## Application for a non-material amendment following a grant of planning permission. Town and Country Planning Act 1990

SINGLE STOREY EXTENSION (MADE A LITTLE WIDER)  
ROOF AMENDED

20/01143/DCH

INCREASE WIDTH OF EXTENSION & REVISE ROOF  
TO ALLOW GLAZING TO REAR ELEVATION

DRAWING No: C655_ST_PL02 -C

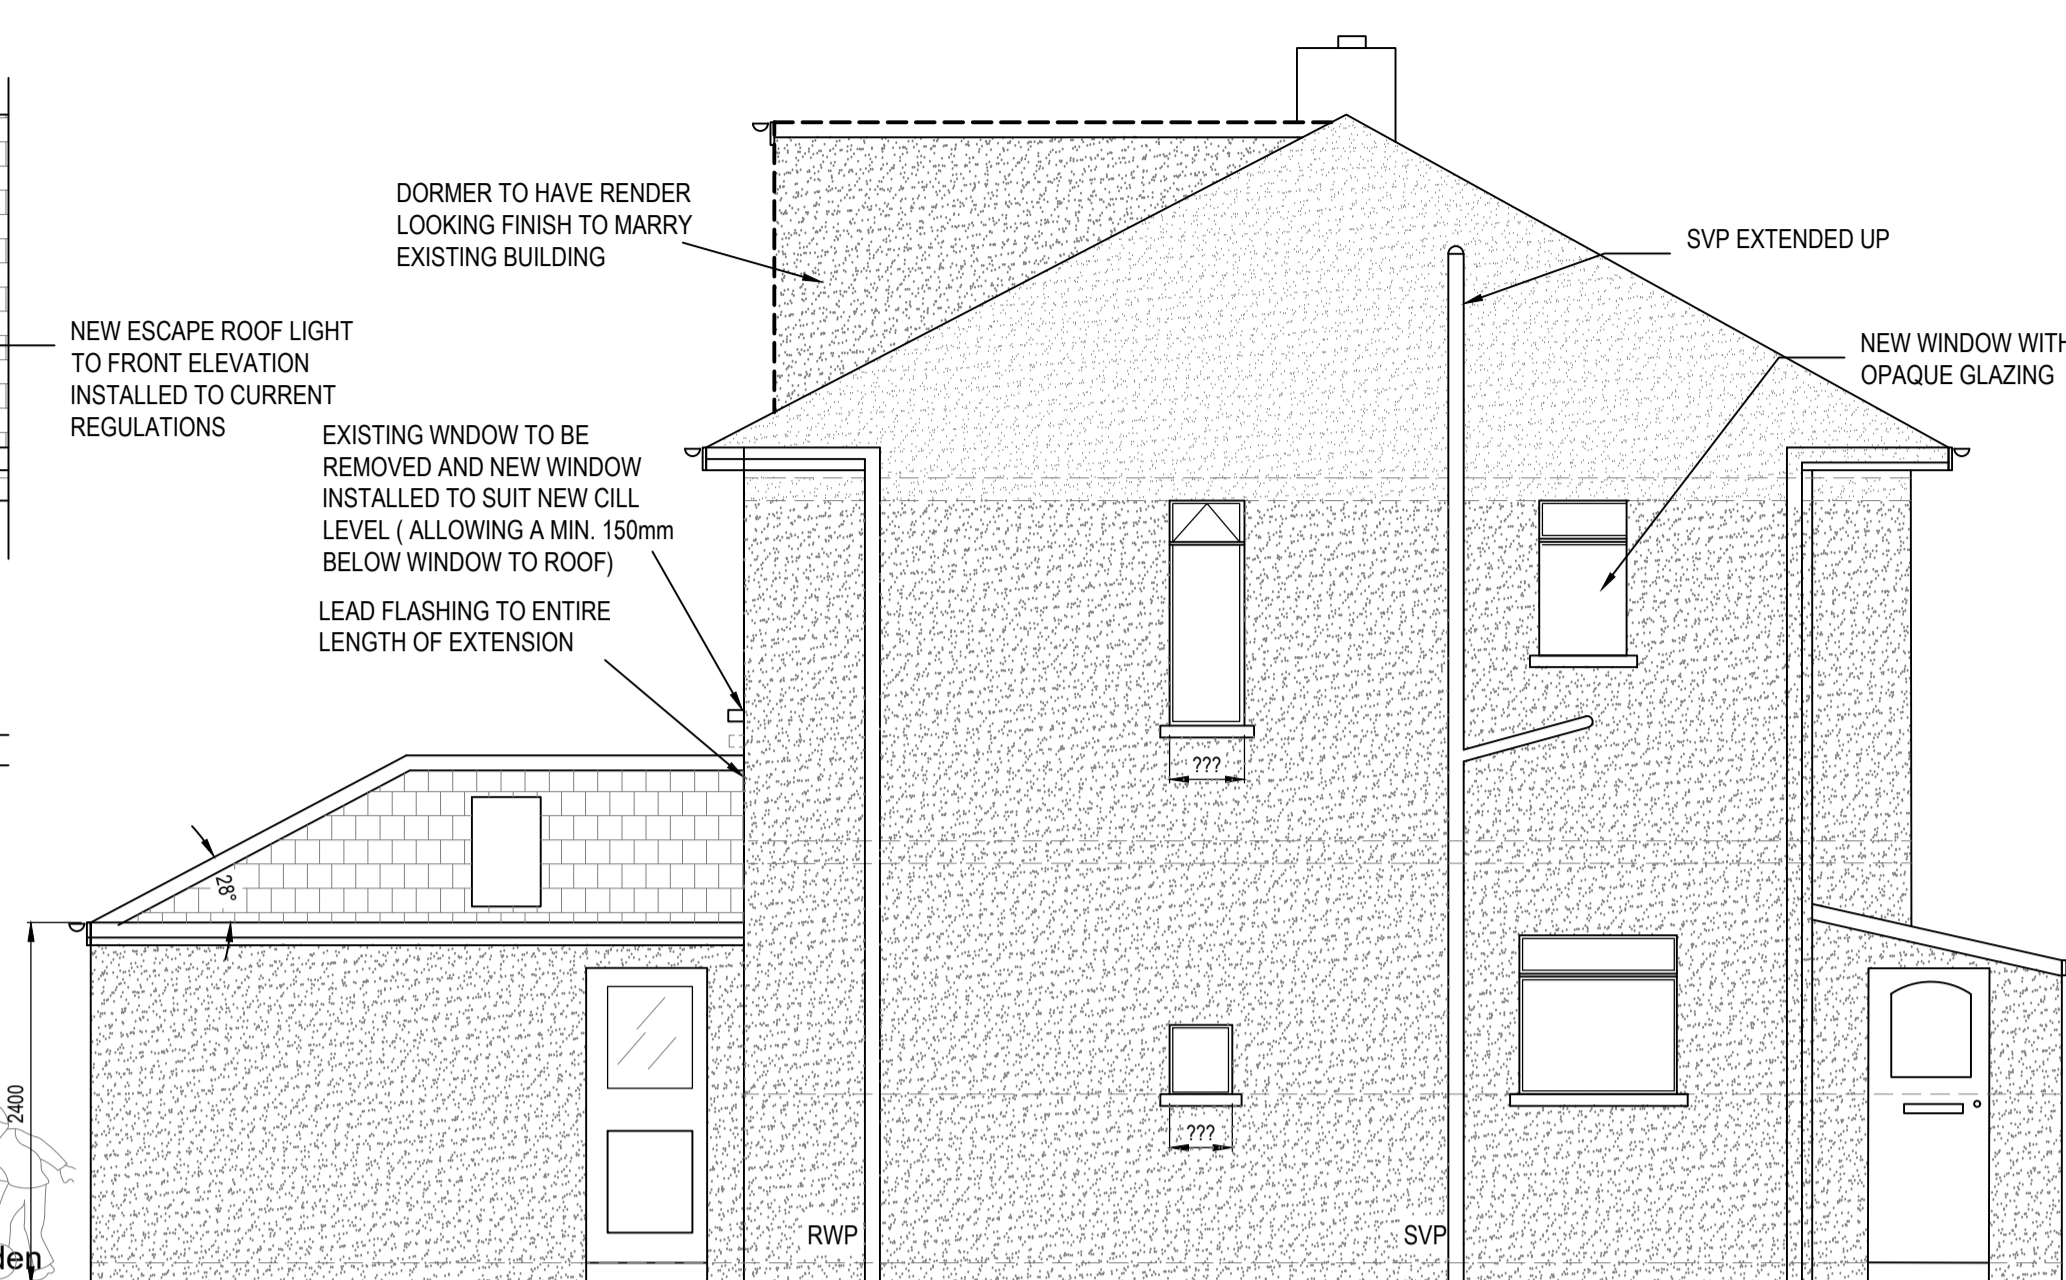
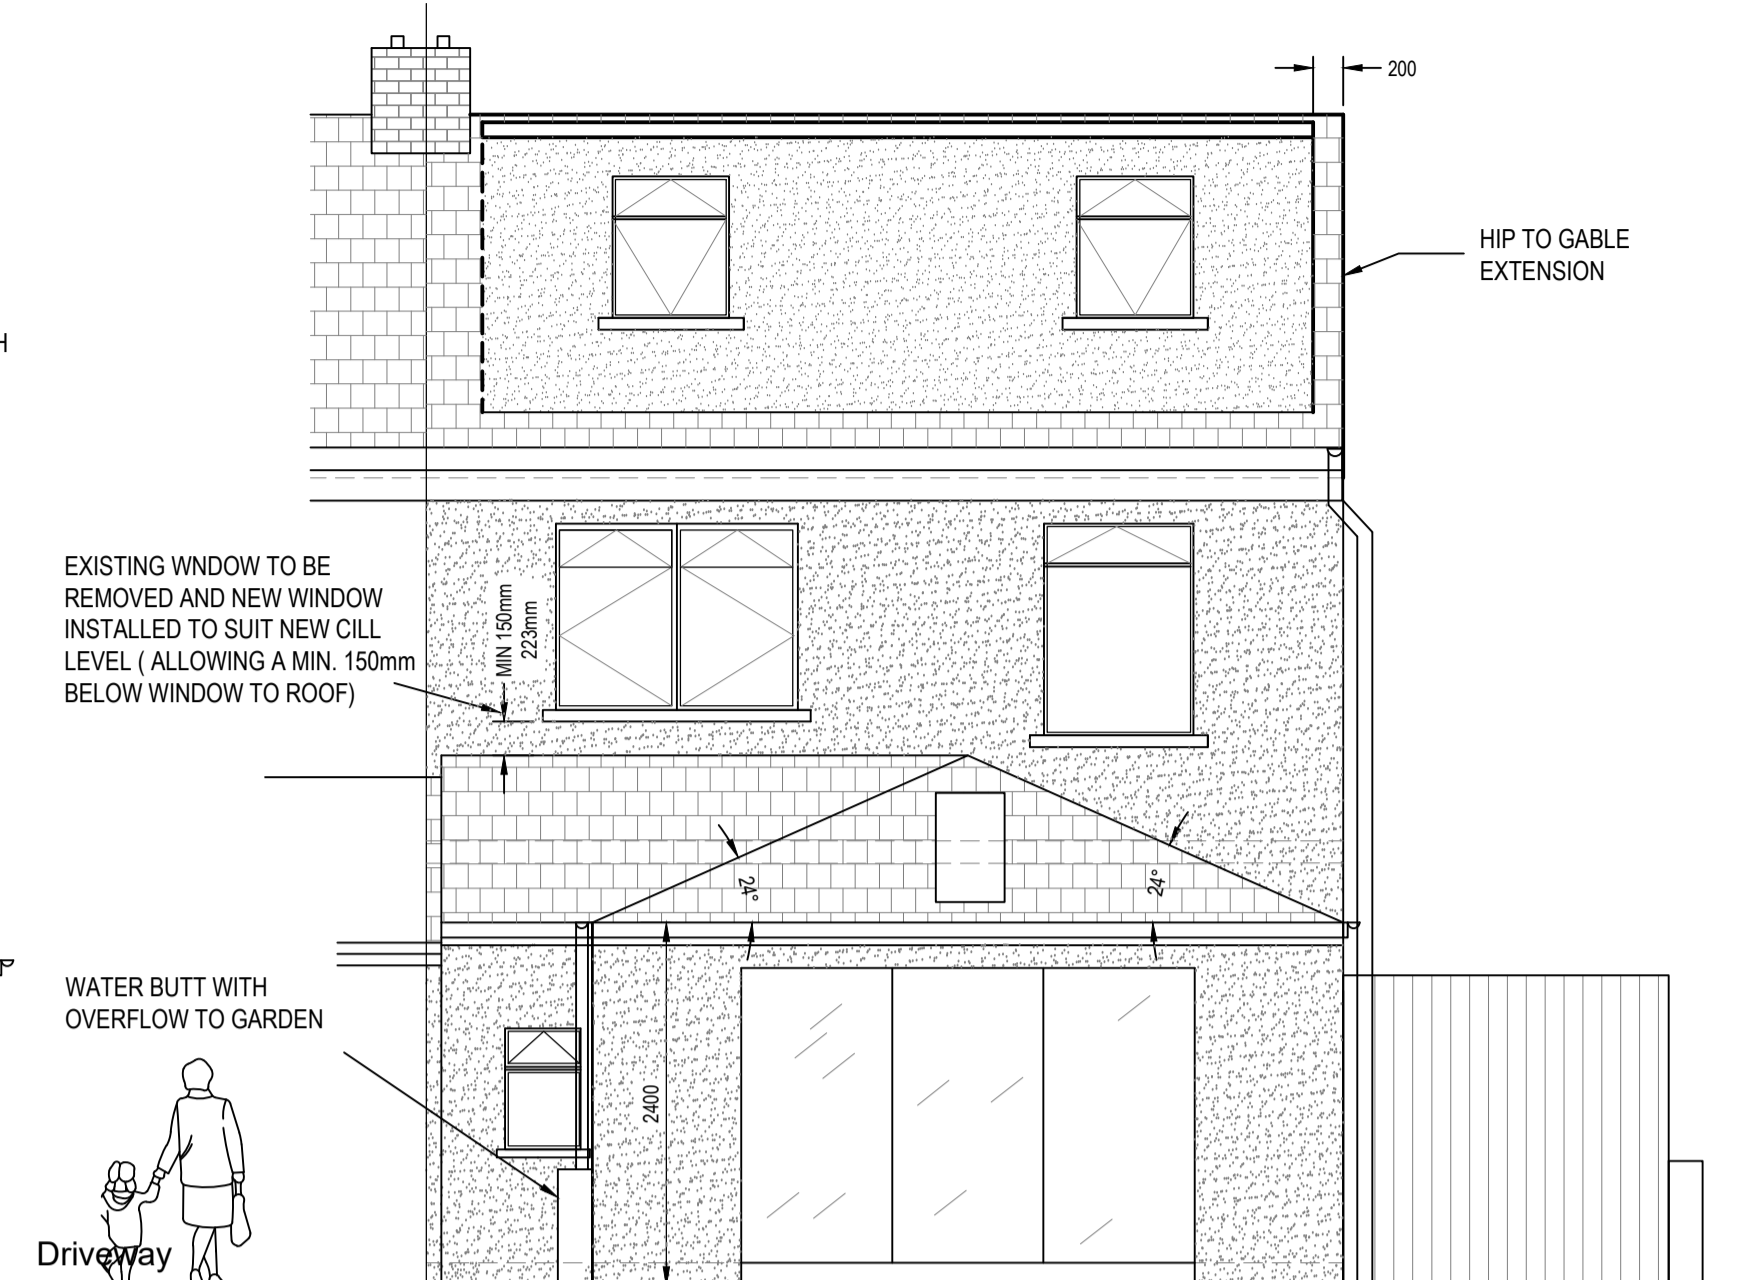
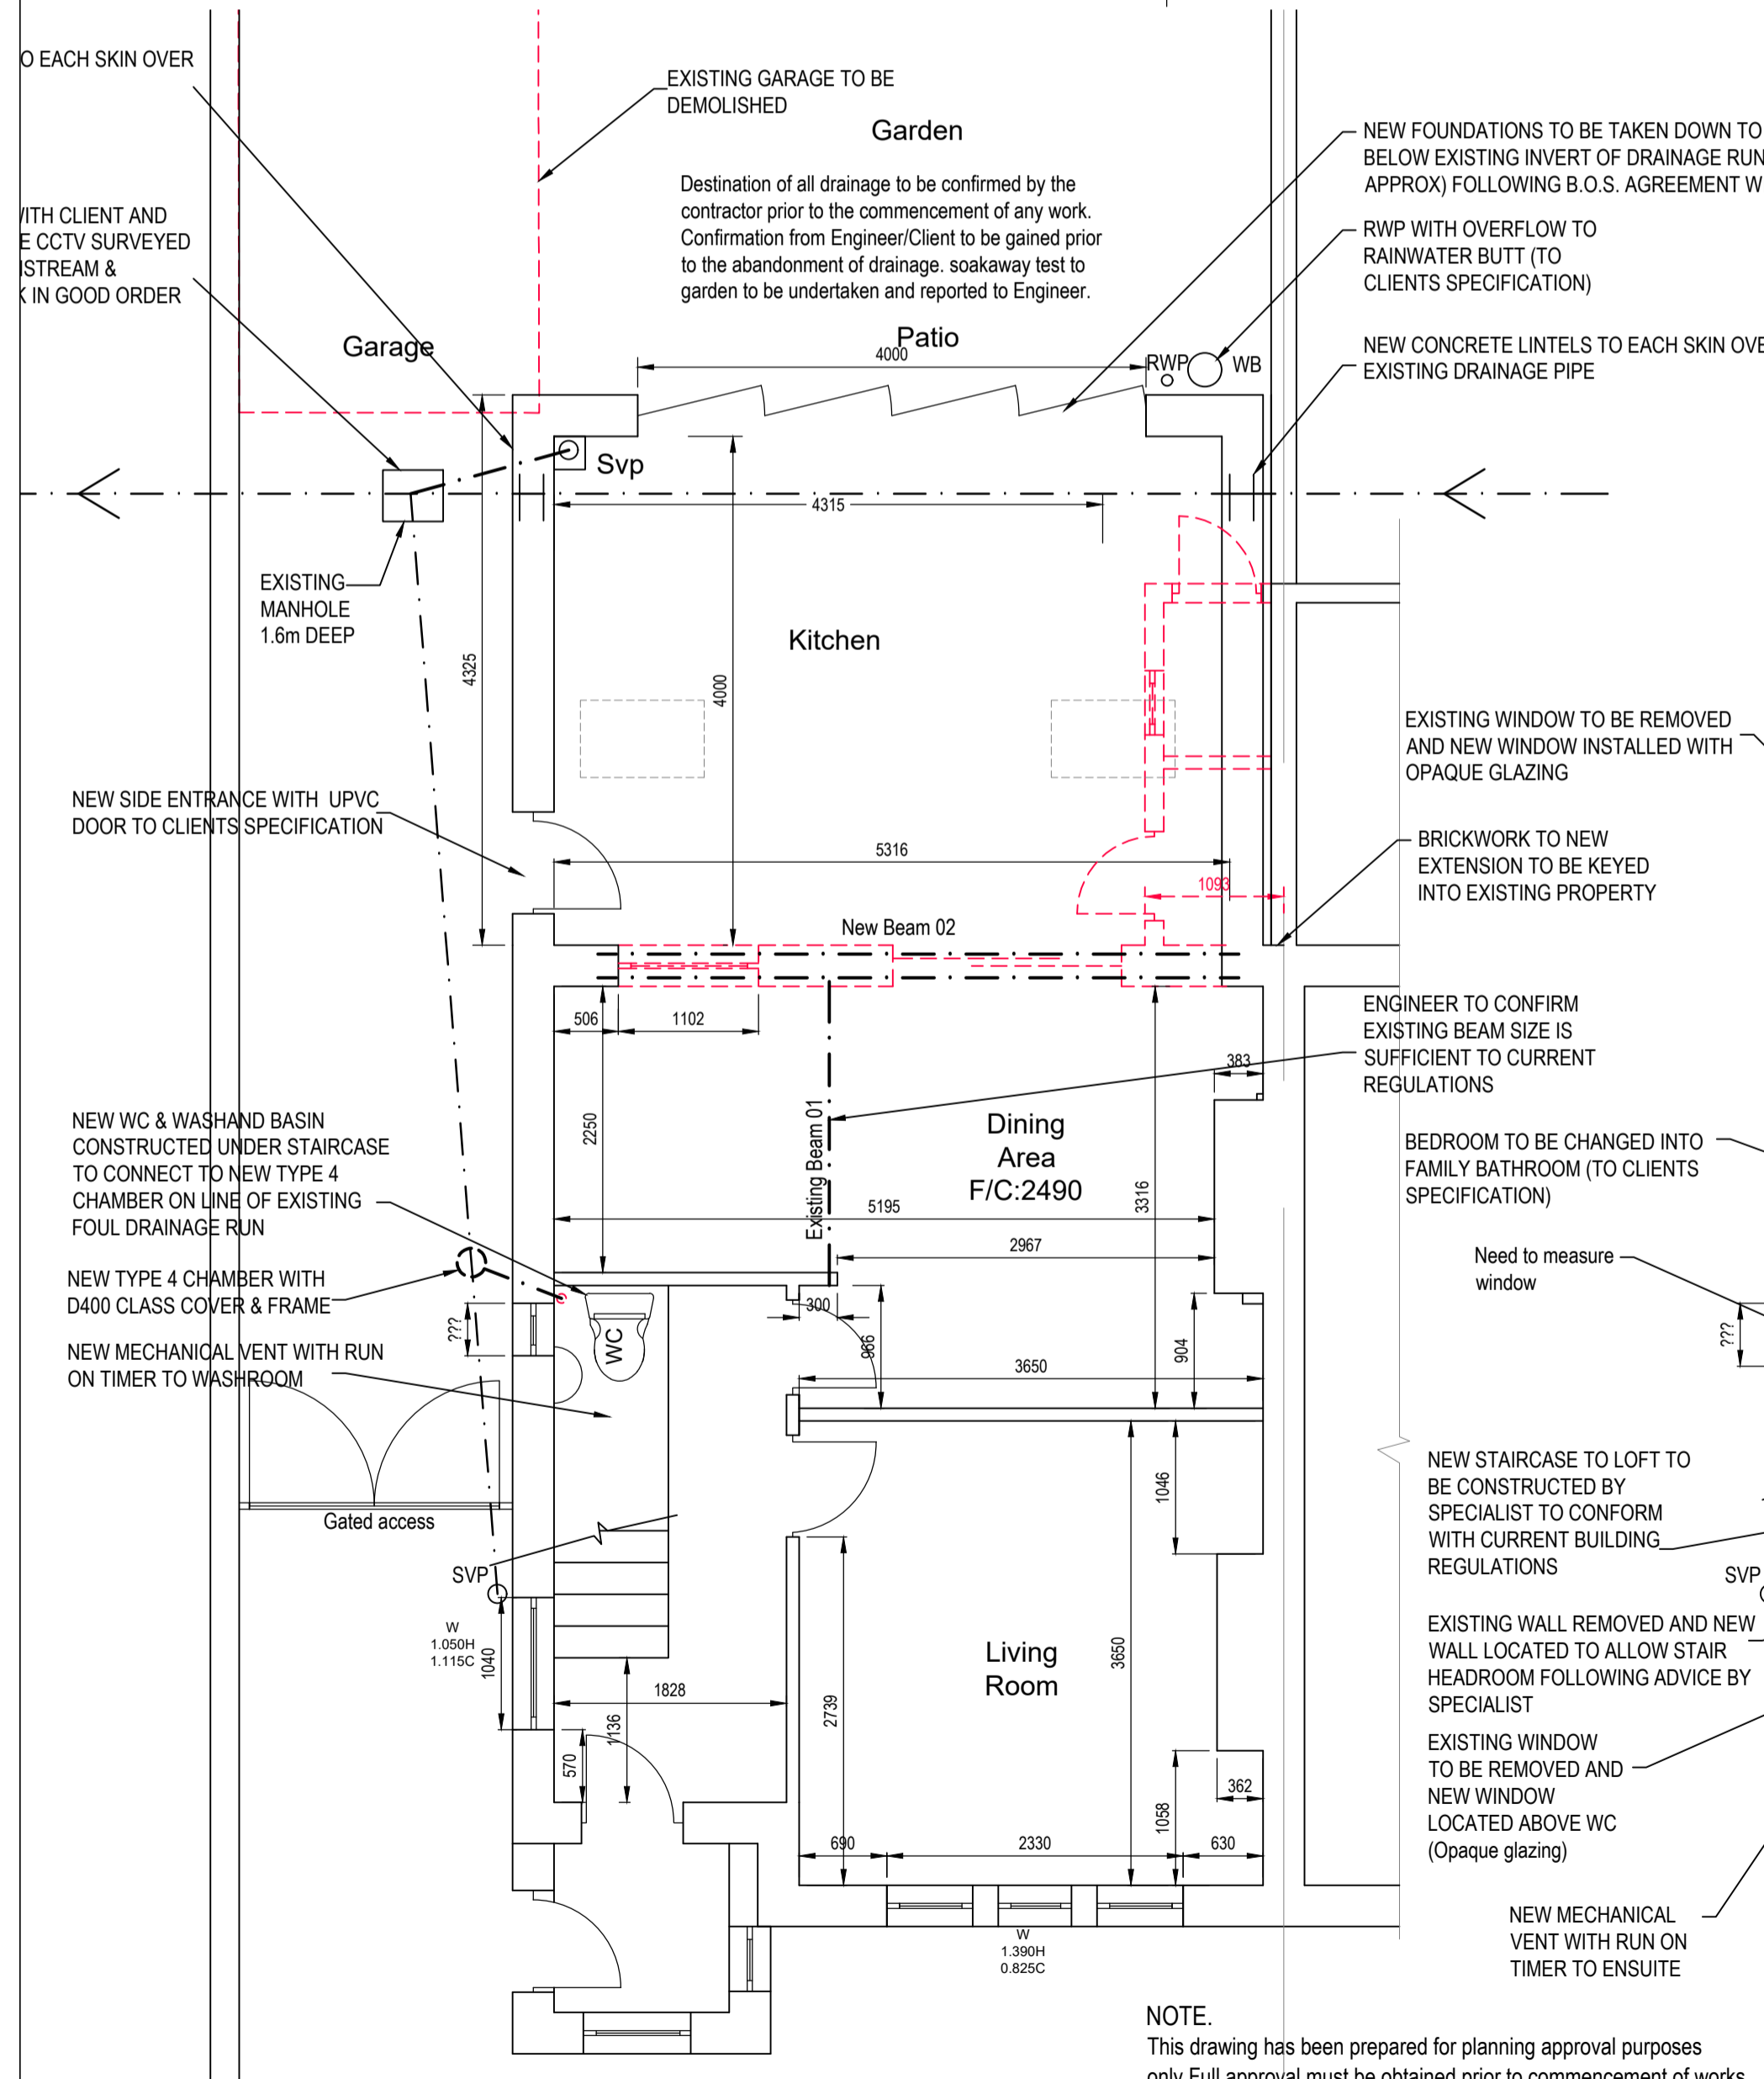
TO ALLOW GLAZING TO TOP OF BIFOLDS @ REAR  
ELEVATION.

C655-ST-PL02-C.
